**Subject: International Indoor Soccer Arena, 1311 Cuesta Arriba CT. NE,  
Albuquerque, New Mexico**

**Re: Responses to comment letter dated August 18, 2011**

**Re: International Indoor Soccer Area, 1311 Cuesta Arriba Ct. NE, Grading Plan  
Engineer's Stamp date 7-14-11 (D16/D00X)**

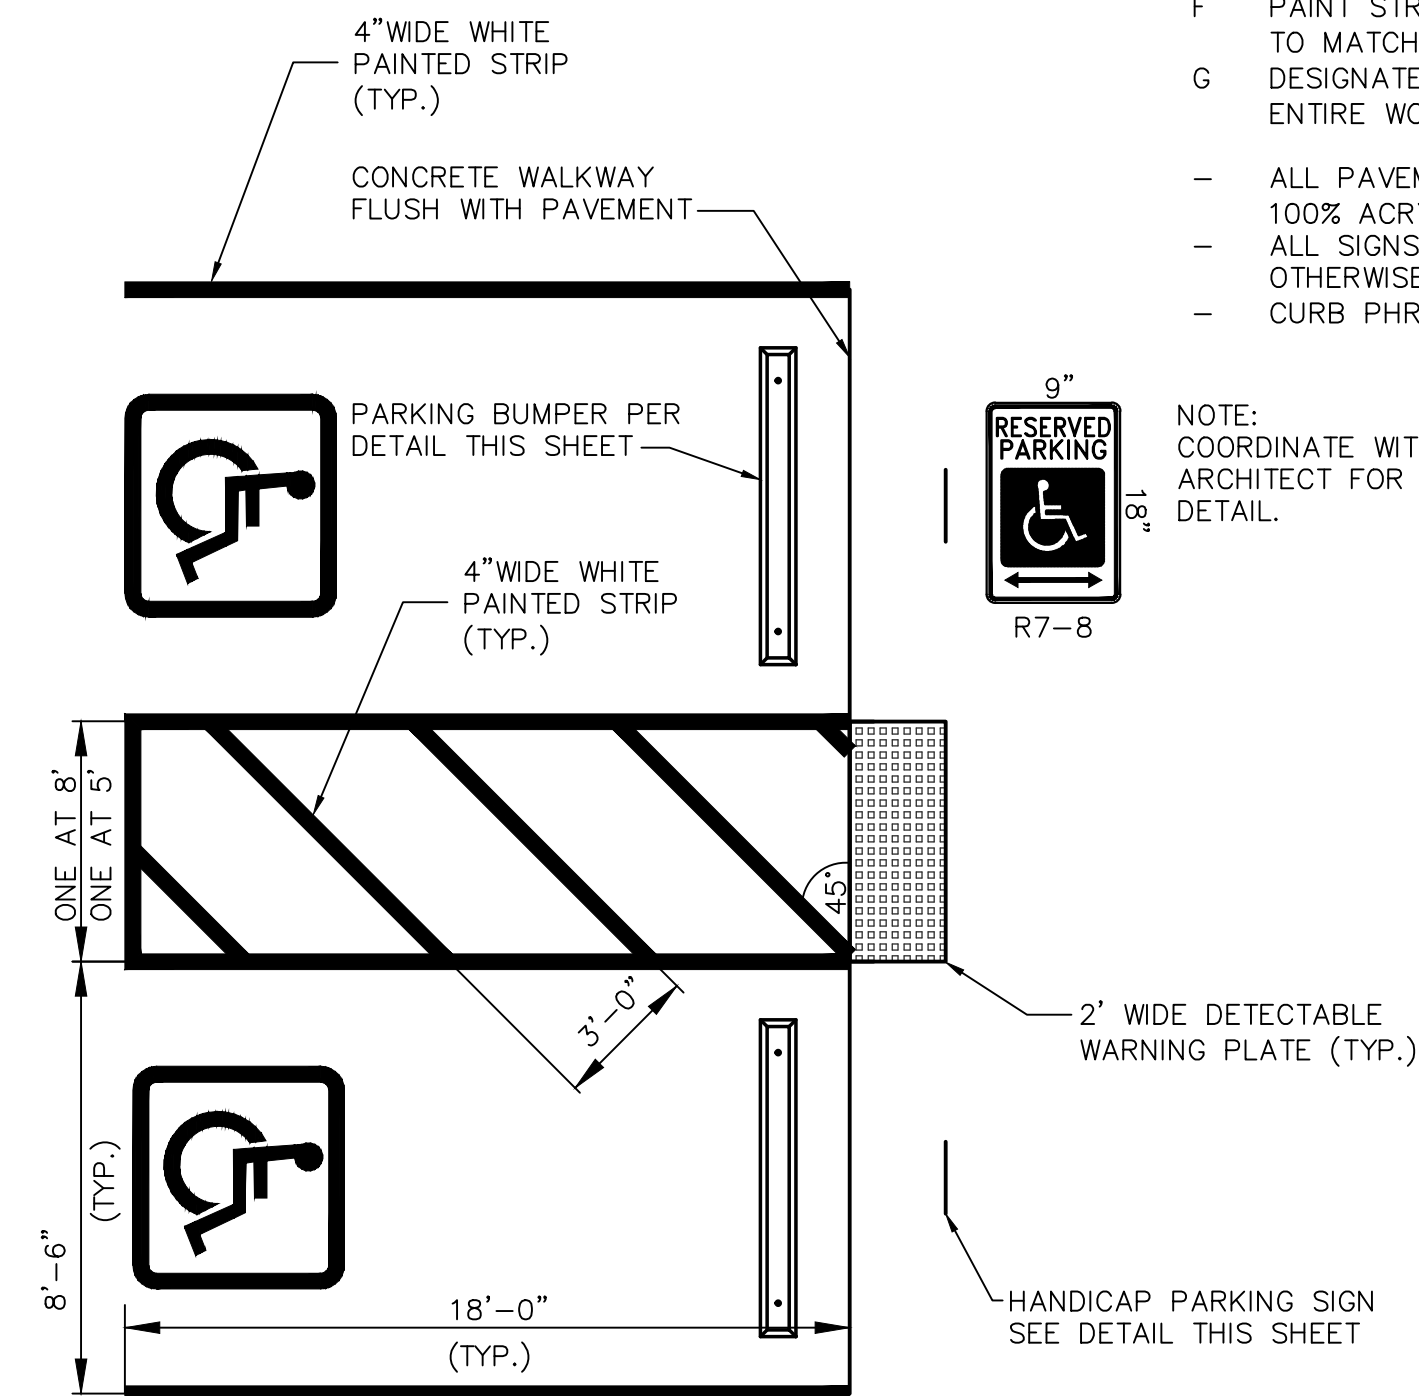
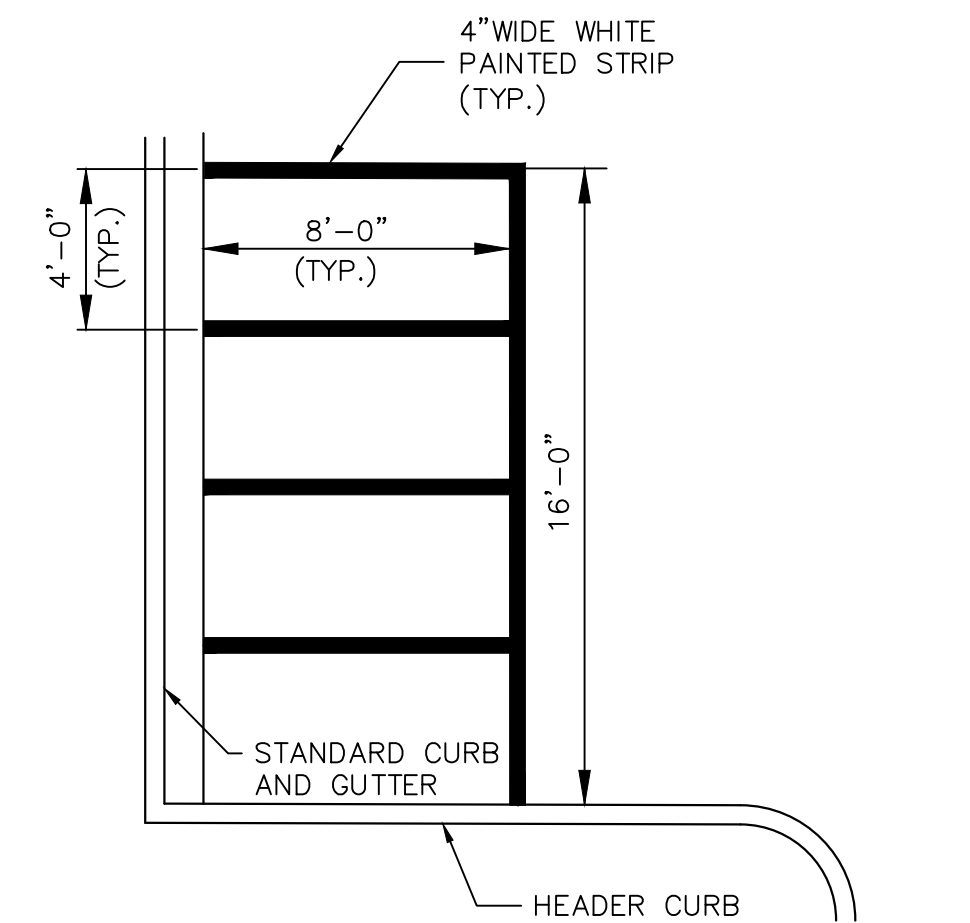
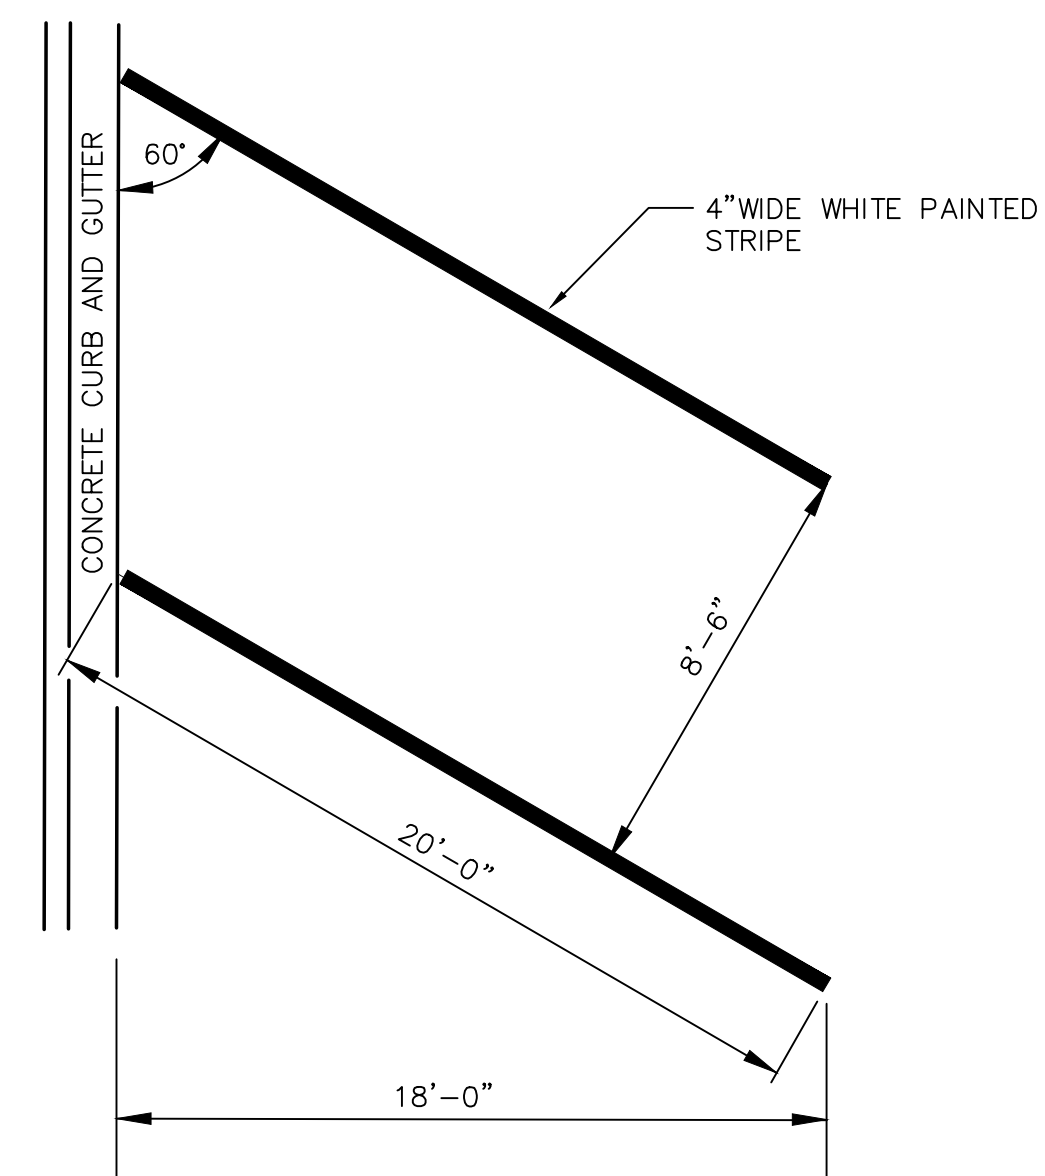
- Please provide spot elevations for the trash enclosure.
  - Please show parking spaces and handicap parking area.
  - Please show the door locations for the building.

- Parking spaces and HC parking are now shown on sheet C-102.
- All door locations to the outside are now shown on sheet C-101.
- The runoff within the westerly landscaped area is now routed to the on-site pavement through a three foot curb cut (sheet C-101).
- All mark-ups and comments have been addressed.
- General note #24 on sheet C-101 now indicate all landscaped areas to be depressed approximately six inches

⑬ ON-SITE SIDEWALK CULVERT  
SCALE: NONE

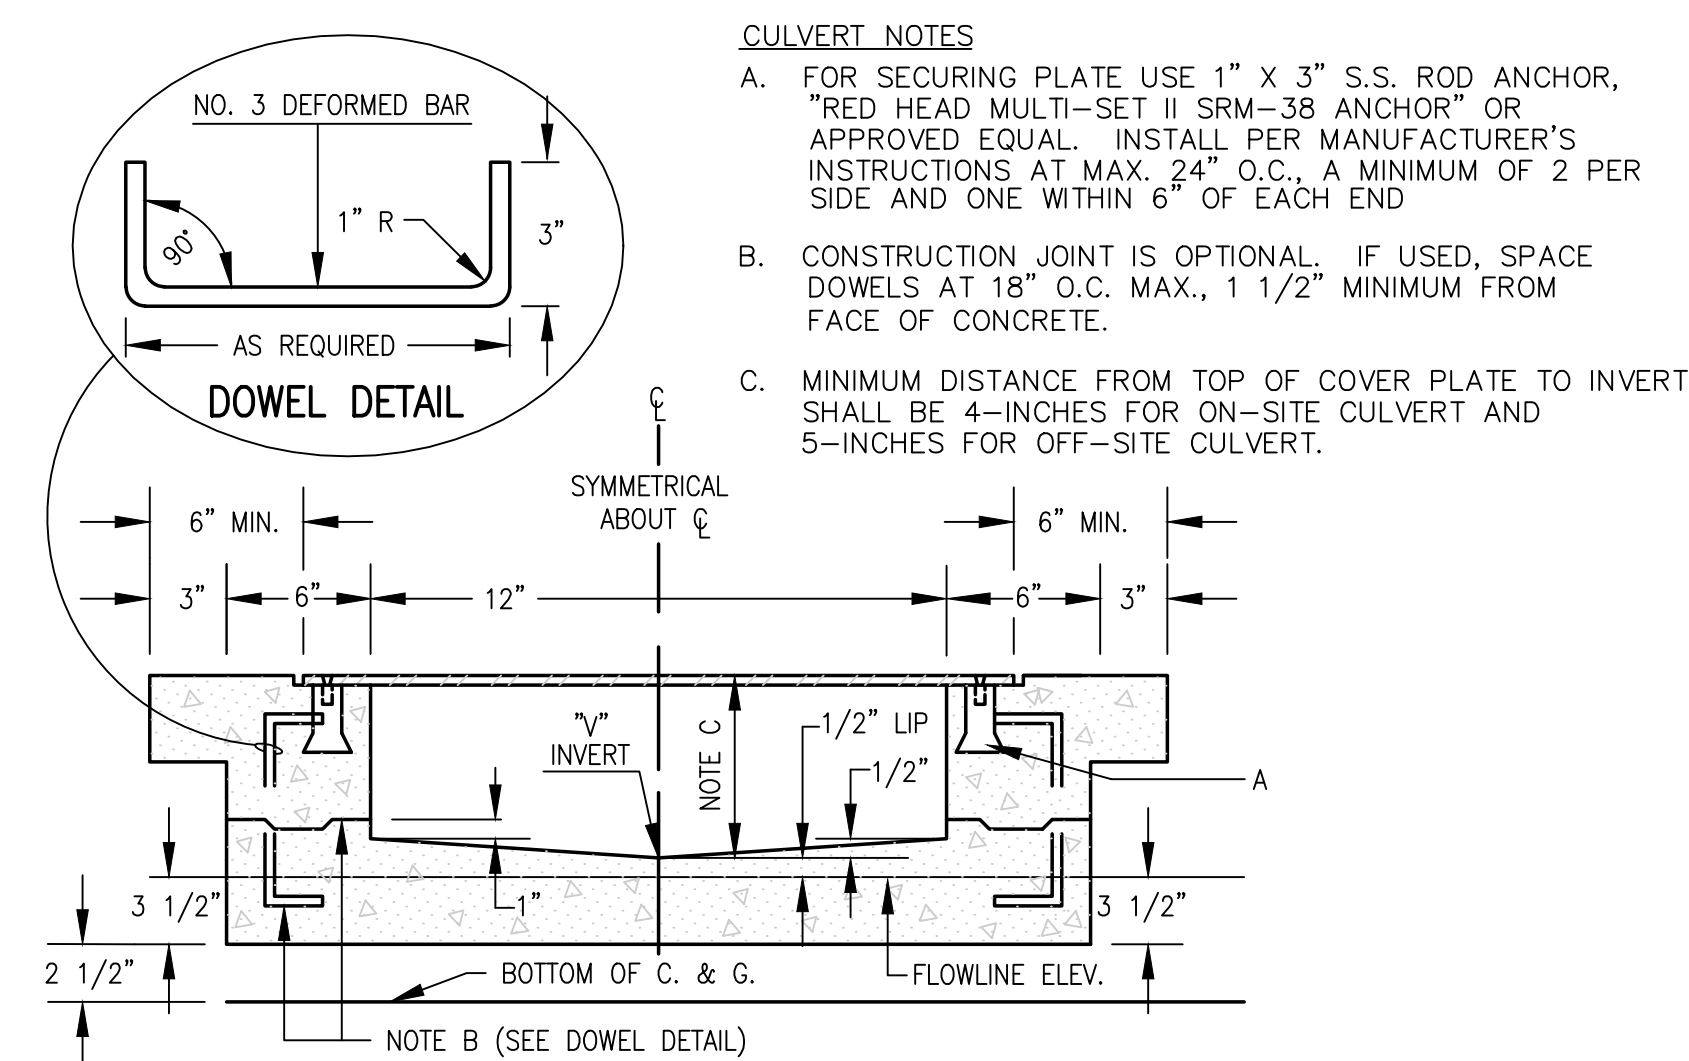
- Provide SO-19 construction notes and signature block for the construction of the sidewalk culvert.
  - Please use the attached revised copy of the sidewalk culvert on your plans.

- SO-19 construction notes and signature block now provided on sheet C-101.
- Sidewalk culverts within the ROW are now referenced to COA Standard Detail 2236, latest edition. On-site culverts are referenced to detail-13 shown on sheet C-103.
